Reference No:	2023/62/90686/W
Site Address:	8, Bayfield Close, Hade Edge, Holmfirth, HD9 2QX
Description:	Demolition of existing porch and erection of rear extension and alterations
Recommending Officer:	Laura Yeadon

HOUSEHOLDER DELEGATED REPORT

Application Number	2023/90686
Location	8, Bayfield Close, Hade Edge, Holmfirth, HD9 2QX
Proposal	Demolition of existing porch and erection of rear extension and alterations
Publicity end date	Thursday 13 th April 2023
Number of representations received	None
Kirklees Local Plan Allocation/Designation	Unallocated land
Extension to Time (EoT)	N/A EoT Date:
Recommendation	Conditional Full Permission

West Elevation 1:100

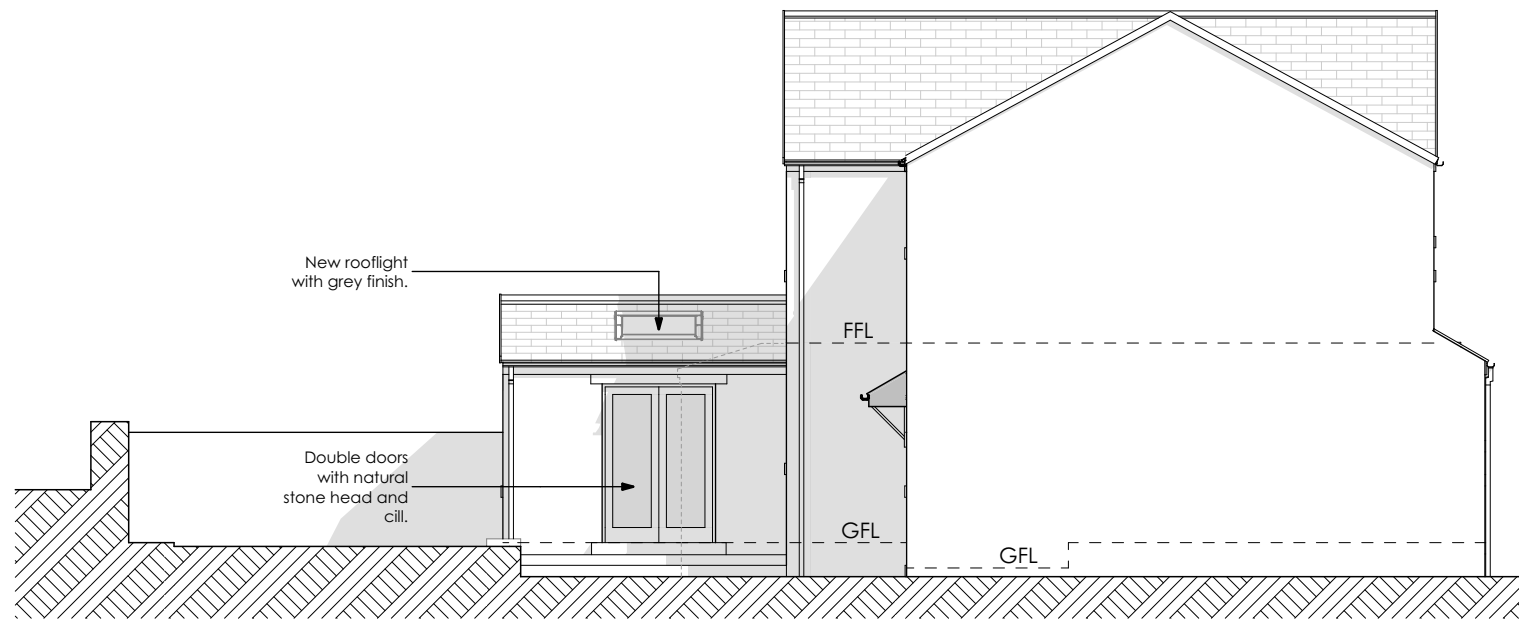
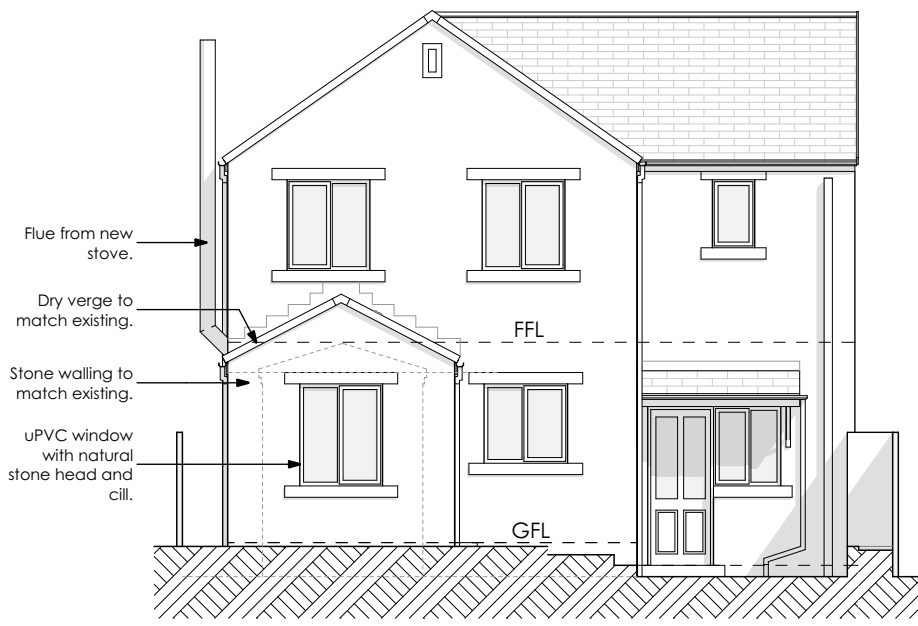
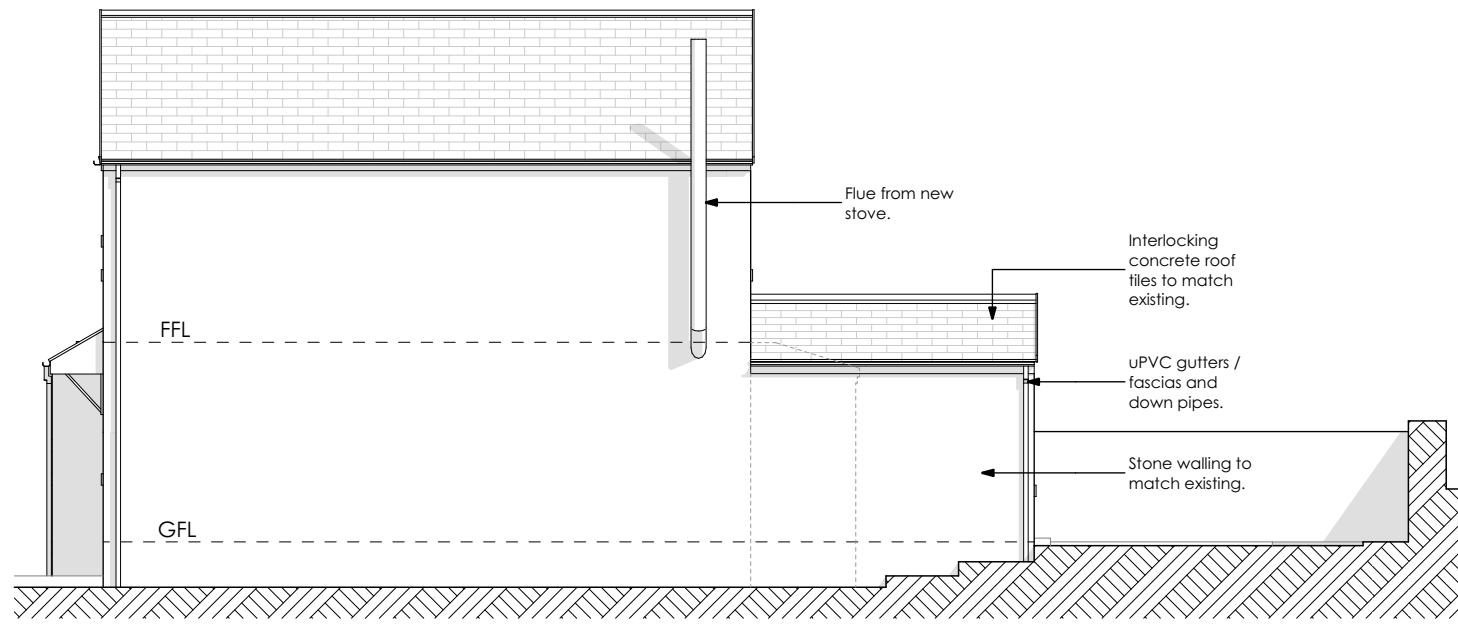
Window proportions	- KDP 1 and 2 of the SPD - Policy LP24 Design (a), (c) and (d) of the KLP - Policy 1 & 2 of the HVNDP	Large openings to rear west elevations and patio doors within south elevation – appear in keeping	✓

Ground Floor 1:50

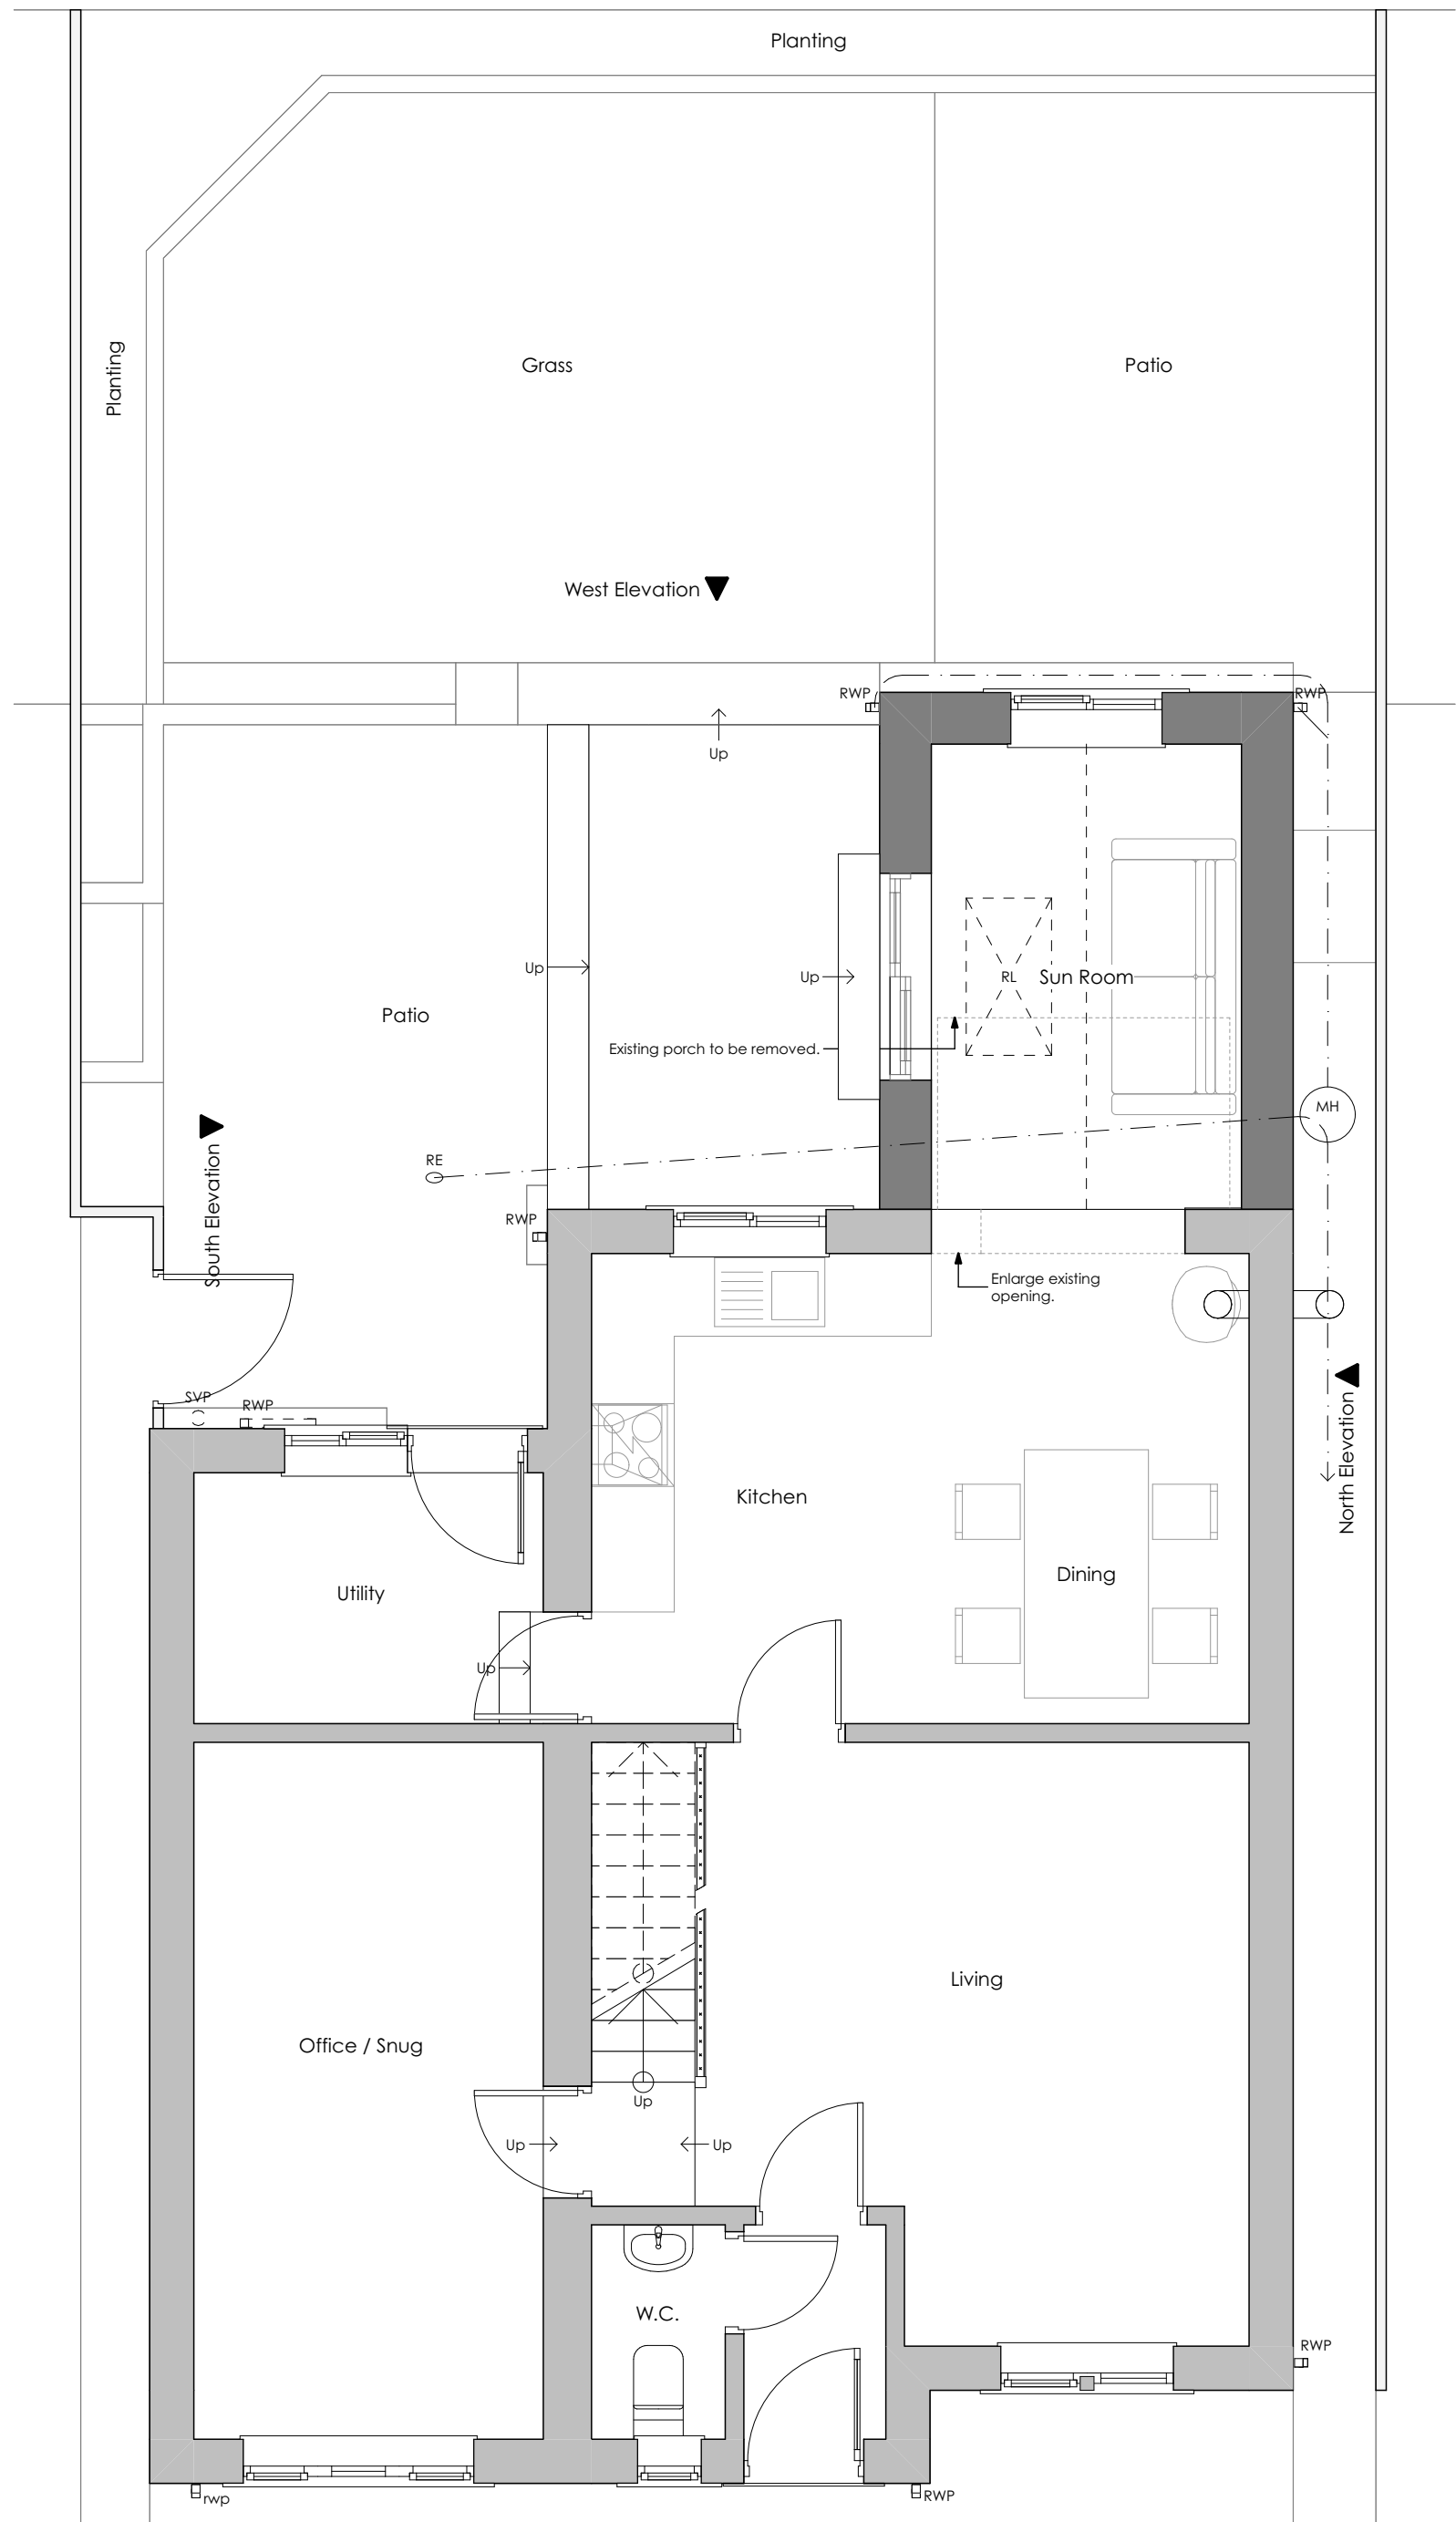
retain a gap of at least 1 metre from a property boundary, such as a wall, fence or hedge		No – would retain 0.6m gap – however given the extension is flush with the existing side elevation – visually acceptable
